# CITY OF PORTLAND BUILDING PERMIT

Located At 15 ALLISON AVE

Job ID: 2012-11-5356-SF

**From:** Jonathan Rioux <JRIOUX@portlandmaine.gov>  
**To:** dkchrist59@yahoo.com  
**Sent:** Friday, November 30, 2012 1:19 PM  
**Subject:** 15 Allison Ave.

CROSS SECTION
SCALE: 1/4" = 1'-0"

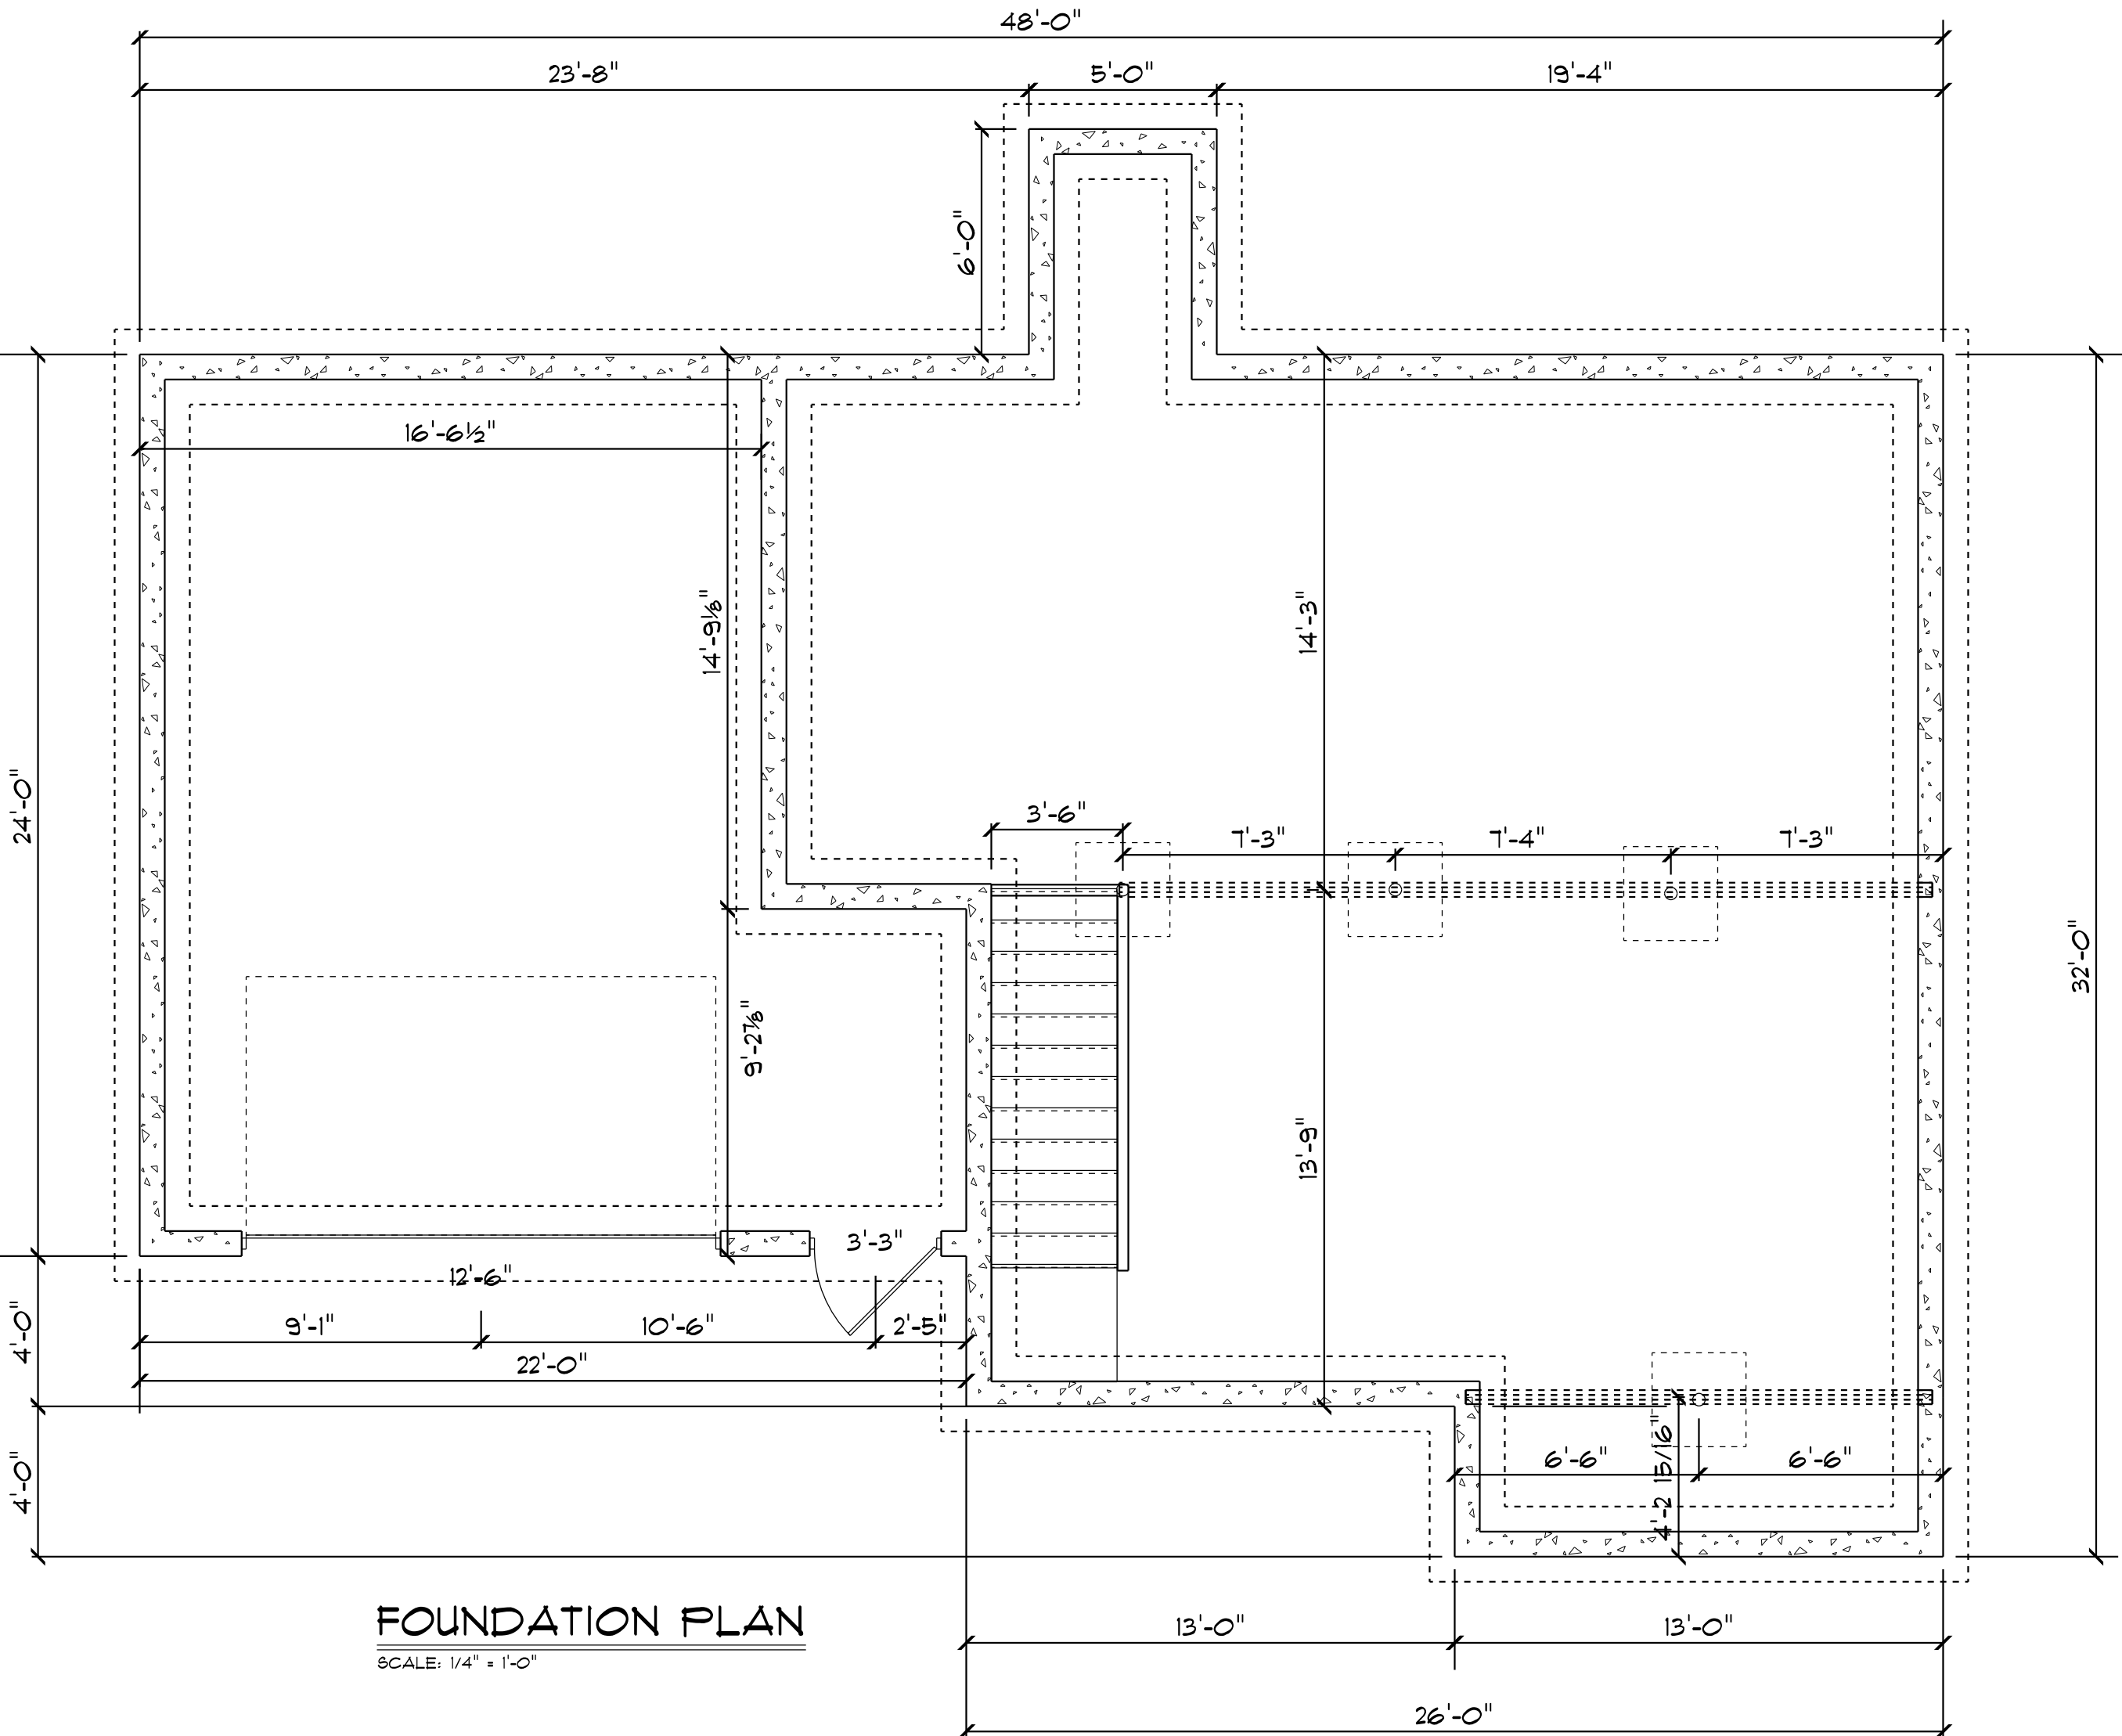
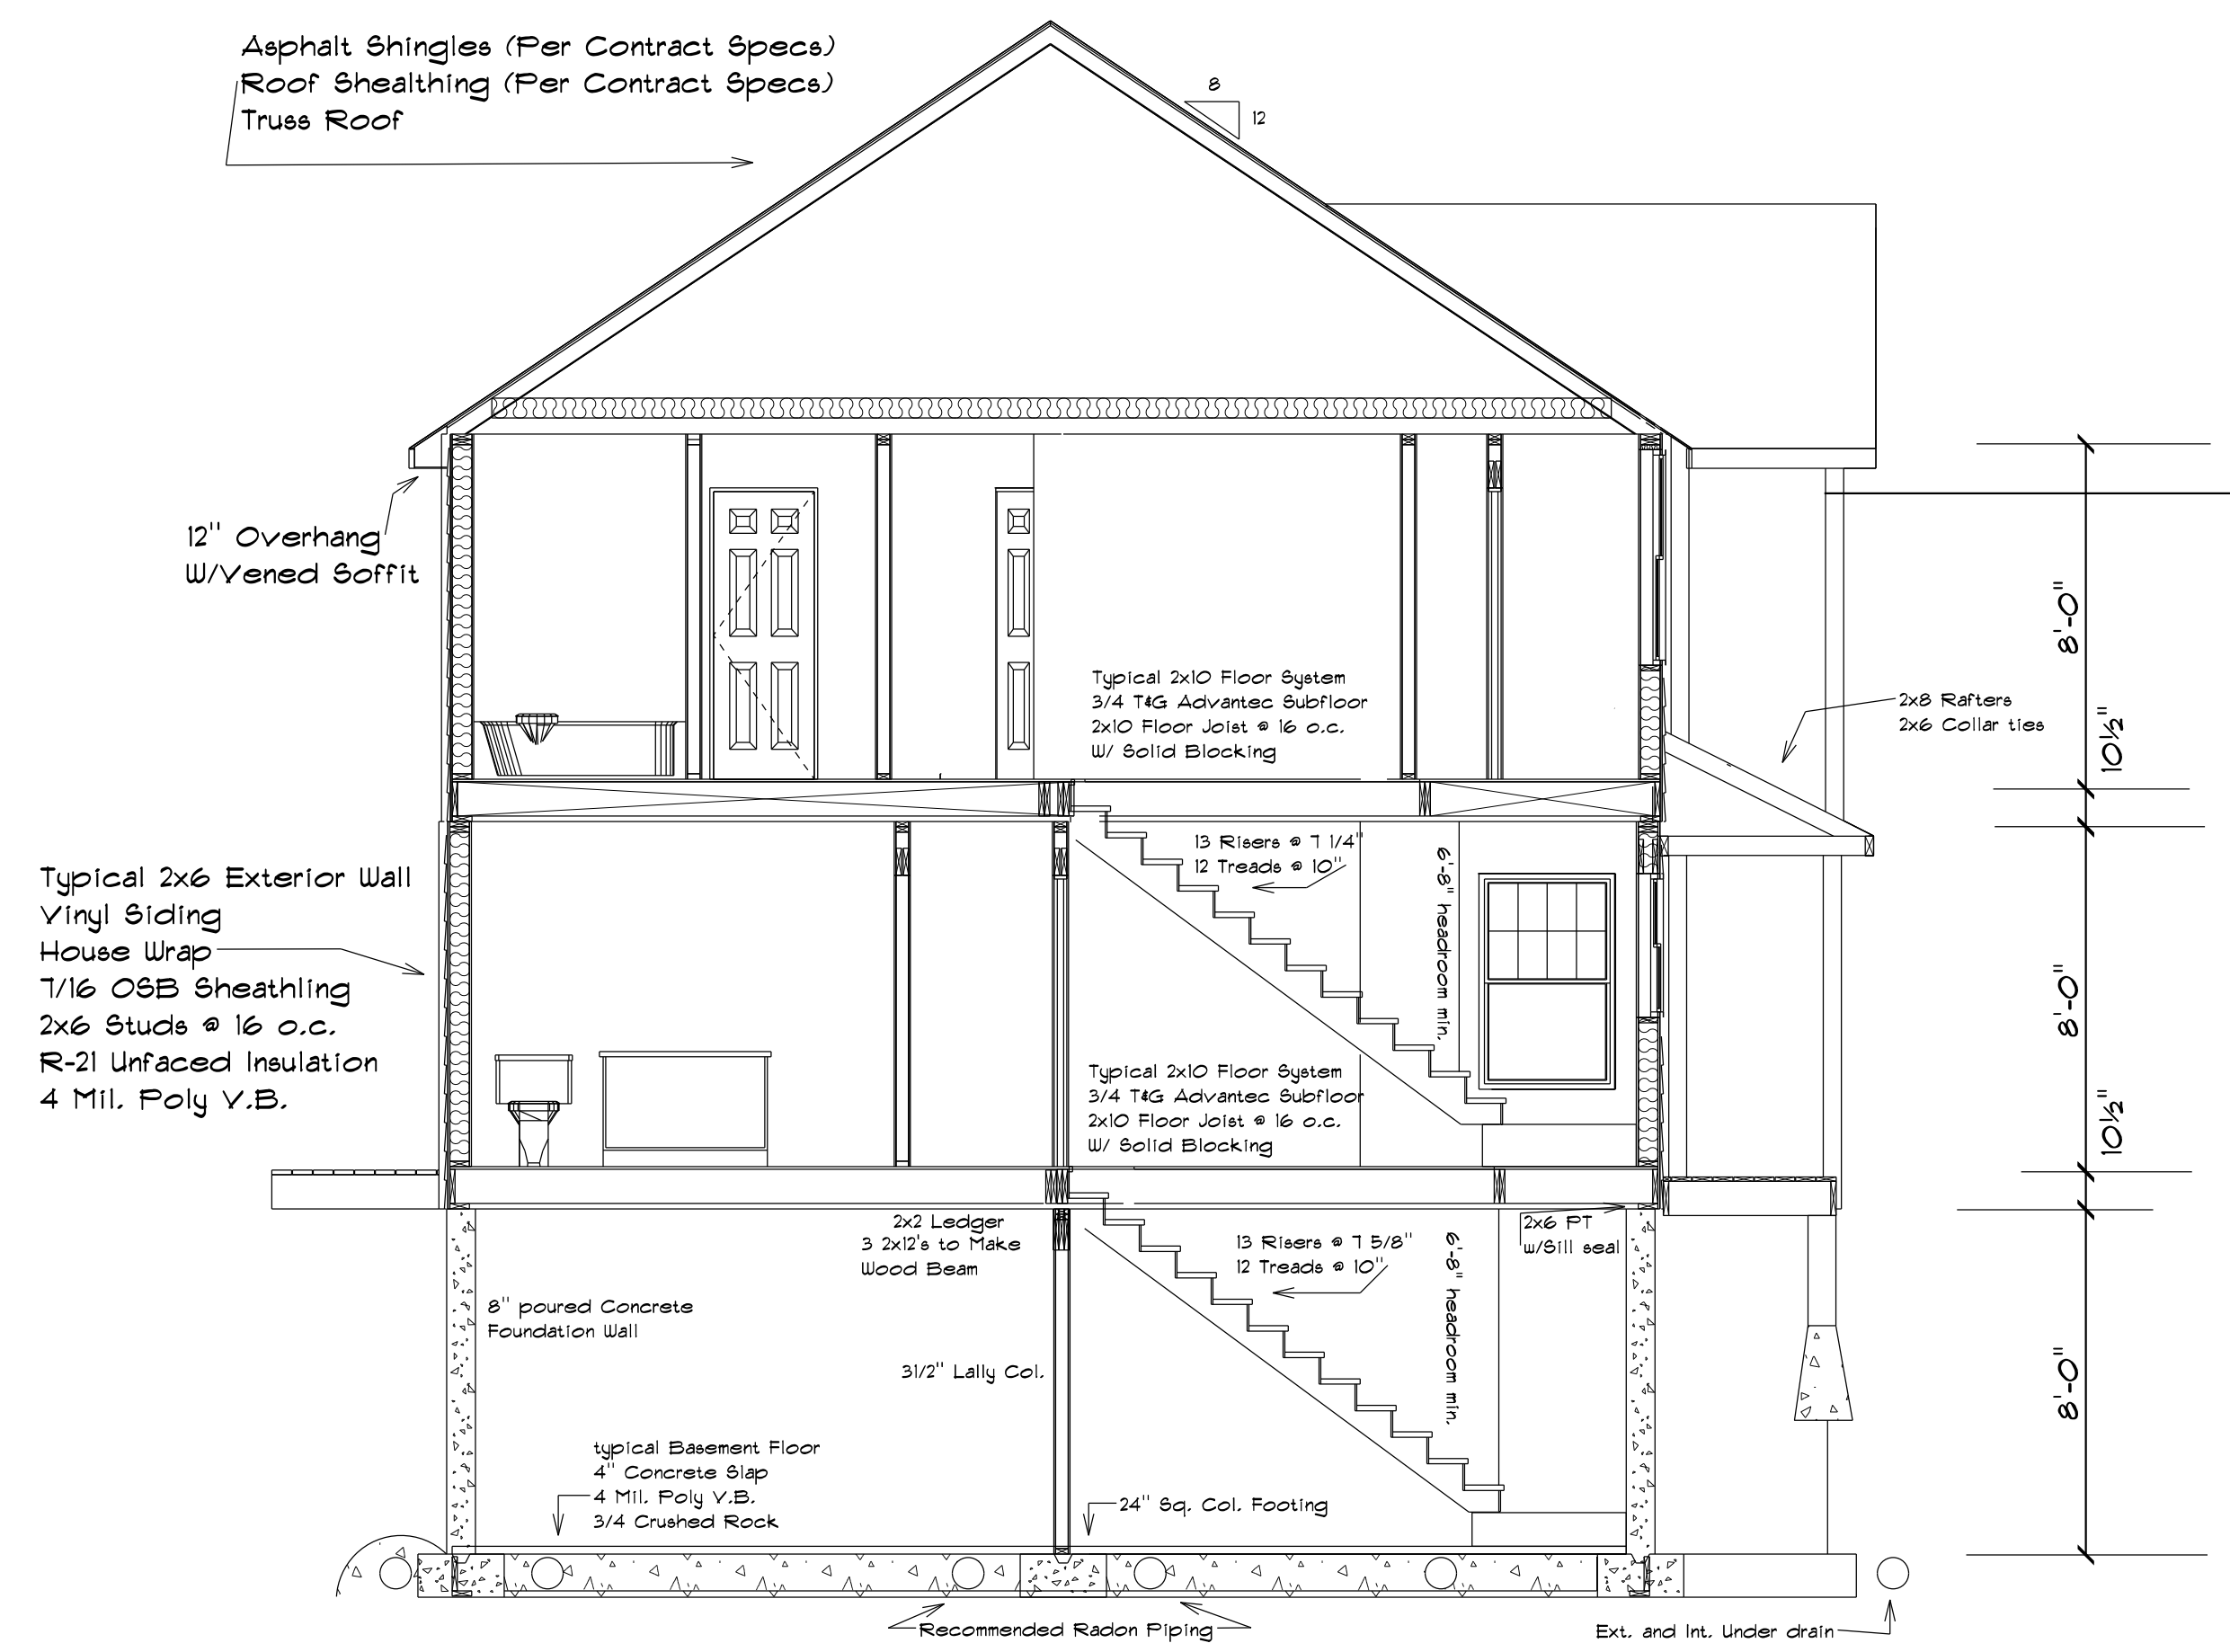
The information below was missing on the building permit application. The floor framing plans/ cross sections need to indicate the (3) 2 x 12 girder spans/ spacing between each lally column; the roof framing plan must show how the dormer meets the 2 by 10 inch rafters, with finished headroom. All bulleted items require a response for permit issuance.

- Footing Dimensions/Depth 20" x 10"
- (Table R403.1 & R403.1(1), (Section R403.1 & R403.1.4.1)
- Foundation Drainage, Fabric, Damp proofing Indicated in the cross section but not spelled out. Also clearly shown in the drainage design
- (Section R405 & R406)
- Ventilation/Access (Section R408.1 & R408.3) shown in cross section at eaves with propa vent and ridge vent at peak
- Crawls Space ONLY
- Anchor Bolts/Straps, spacing (Section R403.1.6) Bolts at 6' o.c.
- Girder & Header Spans between lally columns? (Table R 502.5(2)) on foundation plans
- Built-Up Wood Center Girder shown in cross section

- **Dimensions and Spacing** dimensions are on floor plan. spacing is shown in the cross section
- (Table R502.3.1(1) & Table R502.3.1(2) )

- Roof Rafter; Framing & Connections (Section R802.3 & R802.3.1)
  - Rafter tie connection to top plate? not shown but I use H2.5 hurricane clips
- Fastener Schedule (Table R602.3(1) & (2) ) not shown

Thanks for your feed back. I am wondering if you have a complete set of plans where as most of what you have listed is on the plans. The spacing for the columns is in the foundation plans. The size of the girder is in the cross section. I have attached the plans in case you are missing a page. I started to go through your list and am realizing that I should just schedule a time to meet with you to go through this since I to have questions as to what you are asking for. I will bring in anything that is not listed on the plans with me as you have noted. I will call later to try and set up a time to meet sometime this week.
